REQUEST

Current Zoning: R-8 (single family residential)
Proposed Zoning: UR-1(CD) (urban residential, conditional) & UR-C (CD) (urban residential commercial, conditional)

Approximately .17 acres located at the eastern corner of N. Davidson Street and E. 19th Street in the Optimist Park community.

The petition proposes to rezone to two urban residential districts in order to allow for the construction of two attached dwelling units on the back side of the property at an approximate density of 22.2 DUA while preserving the historic storefront for specific uses allowed in the UR-C zoning district as noted in the conditional plan.

PROPOSED SITE PLAN
A-1.1
OF: TWO

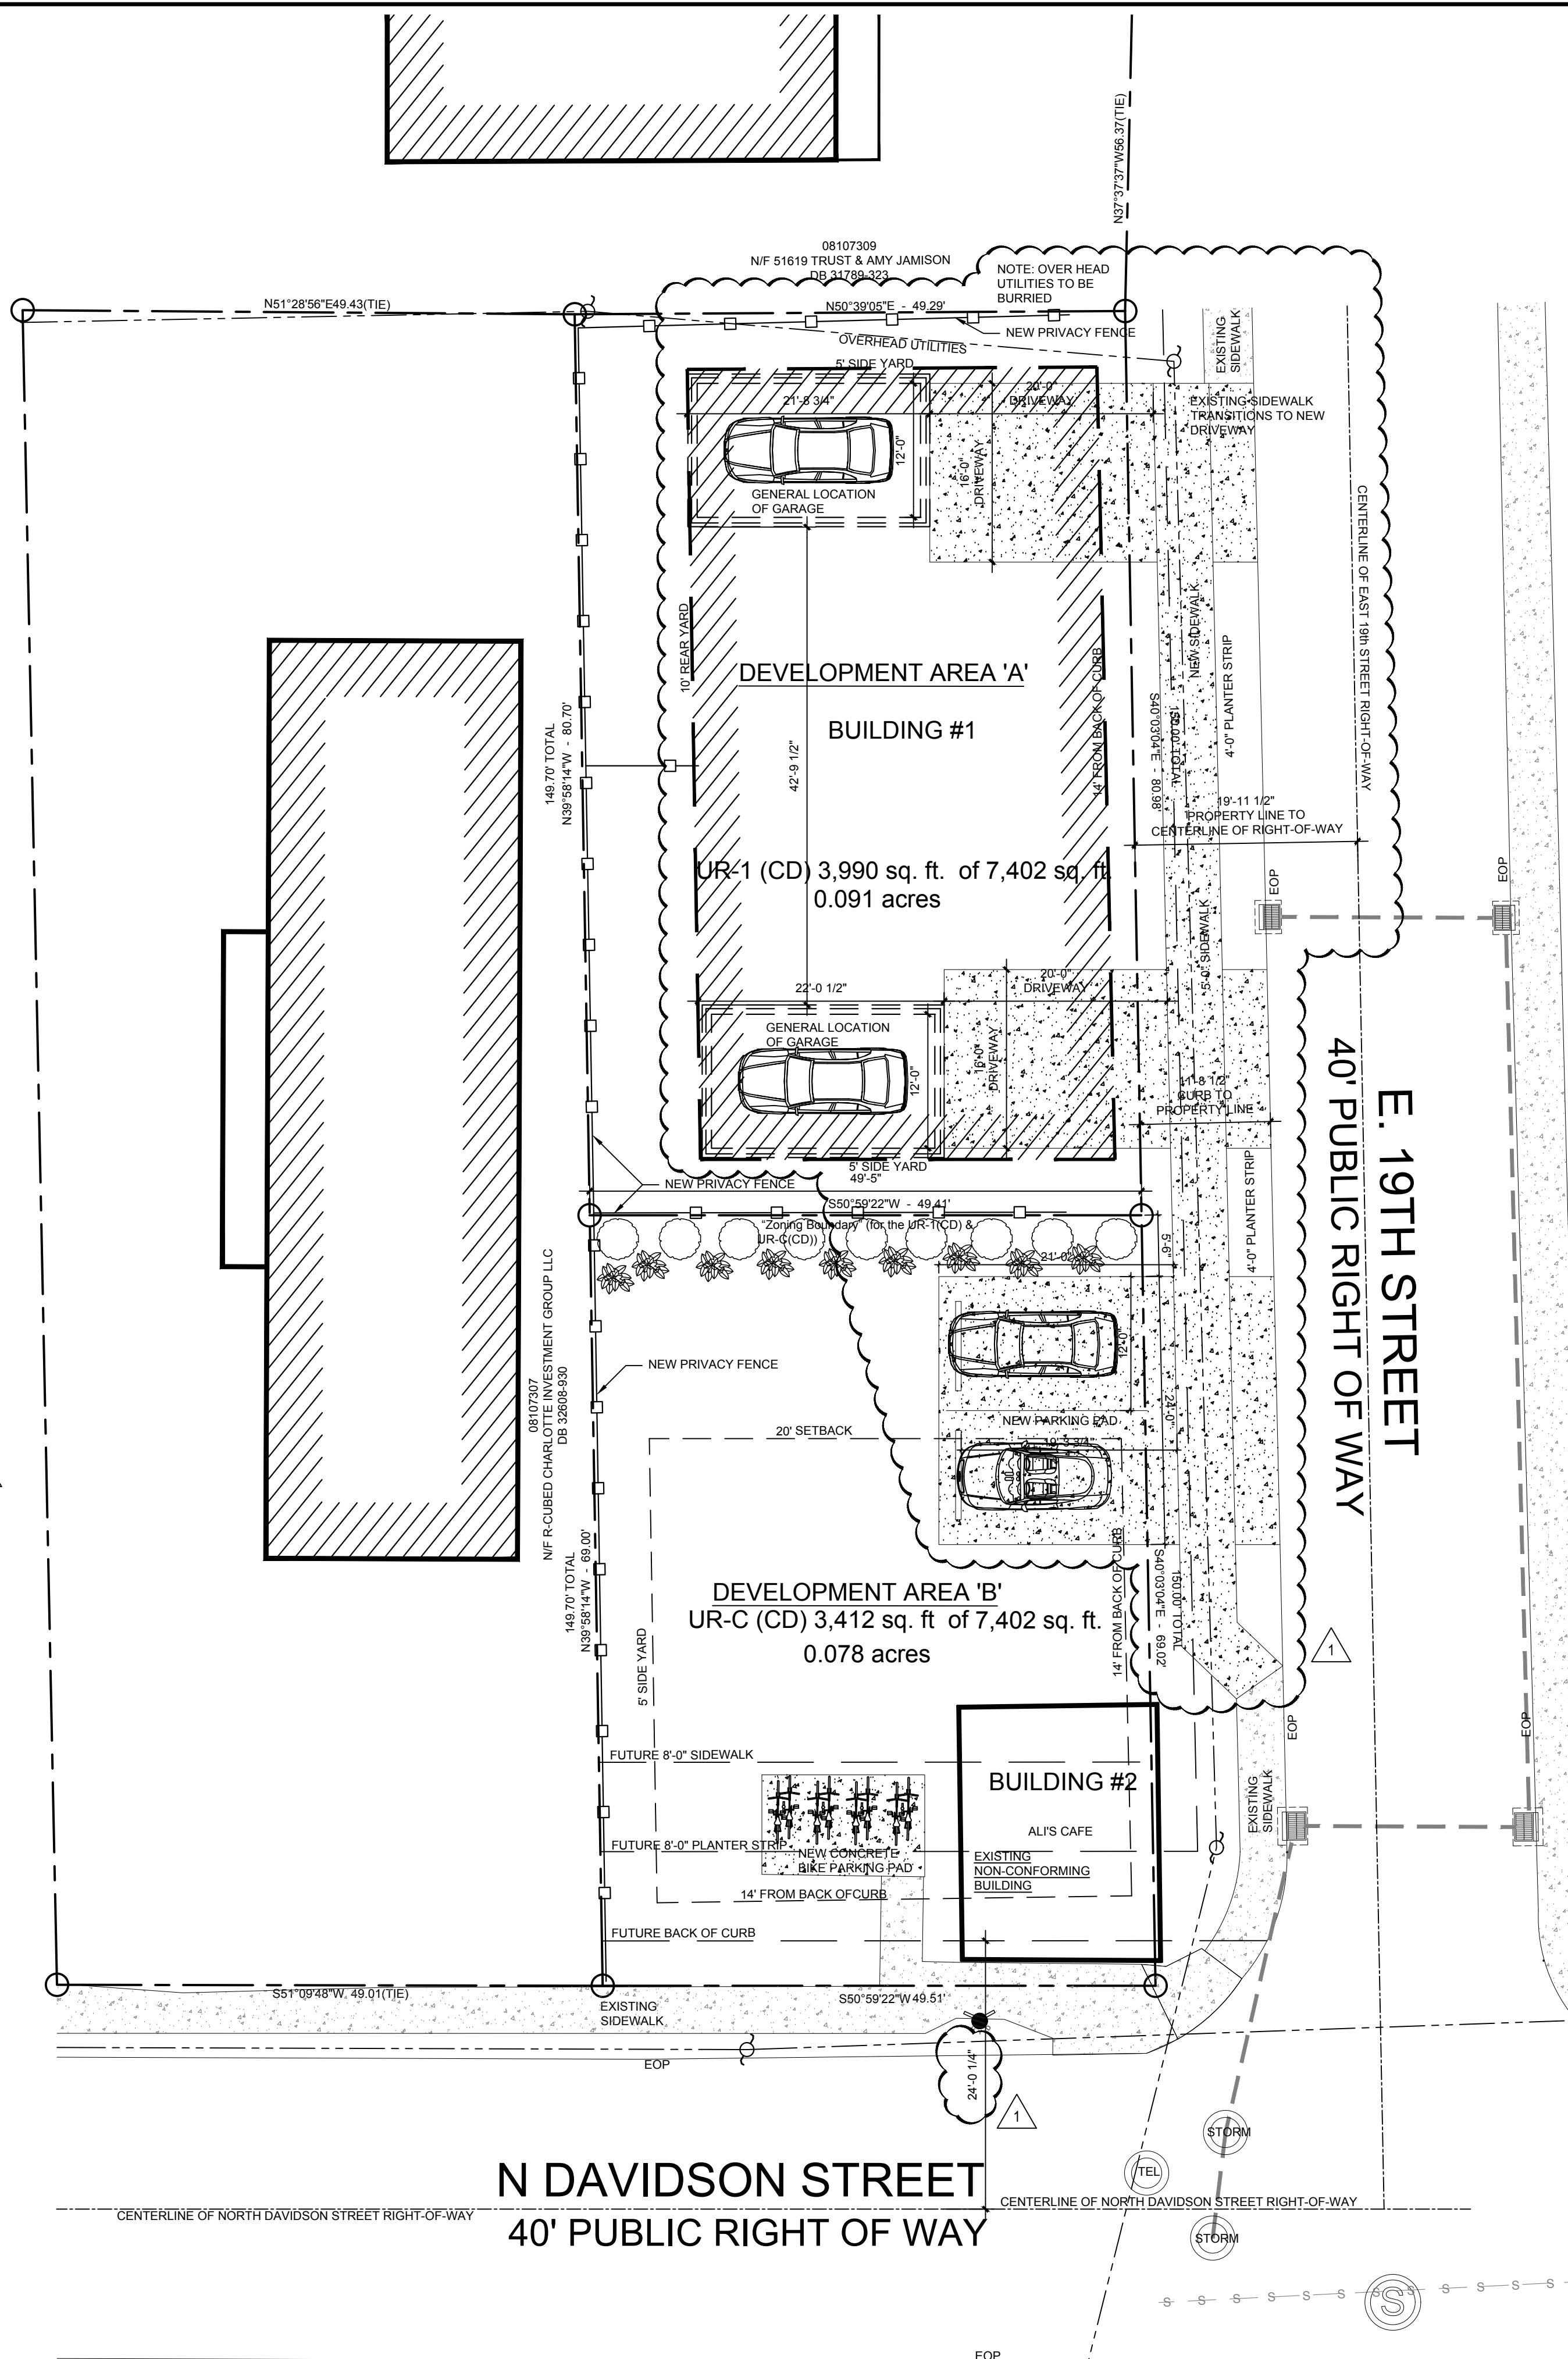
1. Revise the northern portion of the rezoning boundary (the portion requesting UR-1 designation) into a bubble diagram illustrating buildable footprint only.

2. CDOT is requesting the petitioner update the site plan and conditional notes to show and dimension an 8-foot planting strip and 5-foot sidewalk along 19th Street.
3. The petitioner should revise the site plan to add a note specifying dedication and fee simple conveyance of all rights of way to the City before the site's first building certificate of occupancy is issued. CDOT requests right of way set at 2-foot behind the back of sidewalk where feasible.
4. The future location of curb and gutter is 24' from centerline to back of curb. The site plan should show the curb and gutter labeled and dimensioned from the centerline of each road.

5. In the notes table for Development Area B, revise note 3.D to reflect the commitment only and remove any wording that is reflective of the request to add the note. There is no phasing requested in the plan.
6. Move note 1.F to the Transportation section of the notes; remove bolding and underline formatting.
7. Remove note 3.C.
